**Consultation Response from KC,
Lead Local Flood Authority****2025/91184 land off, Bretton Street, Savile Town, Dewsbury, WF12 9BZ****Erection of two storey industrial unit (Use Class E(g)(iii)), with associated car park, service area and other associated works****Date Responded: 22/08/2025.****Responding Officer: Martin Stephenson****Responding Ref: 1****Documents reviewed by the LLFA:**

- KS 826, Flood Risk Assessment, Rev A dated 29/05/2025.
- KS 826/D01, Drainage Strategy, Rev P1 dated 28/03/2025.

Drainage Strategy

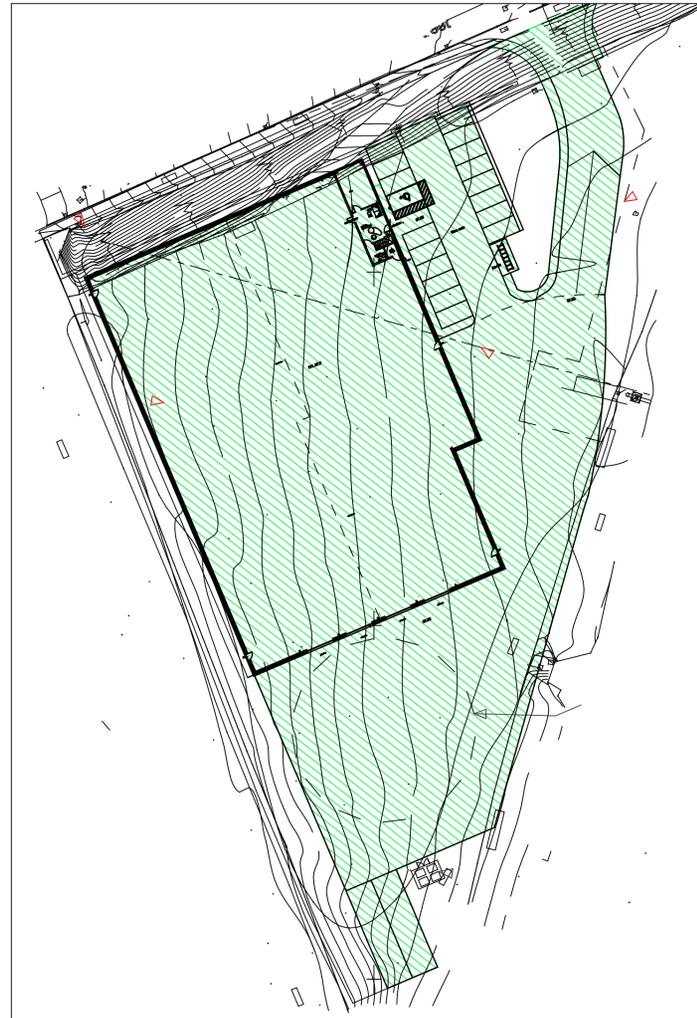
The surface water allowable discharge from the site should be limited to the equivalent greenfield run-off rate (calculated at 5.0l/s per ha of drained area) – subject to a minimum outlet diameter of 75mm for the flow control device.

Hydraulic calculations should be submitted by the developer to confirm that attenuation storage volume is sufficient to store the design rainfall event without flooding off site.

If discharge of the attenuated surface water run-off to the canal (as shown on the Drainage Strategy drawing) is not approved by the Canal Trust, as an alternative, it should be connected to the Yorkshire Water Surface Water sewer crossing the site (subject to agreement with YW).
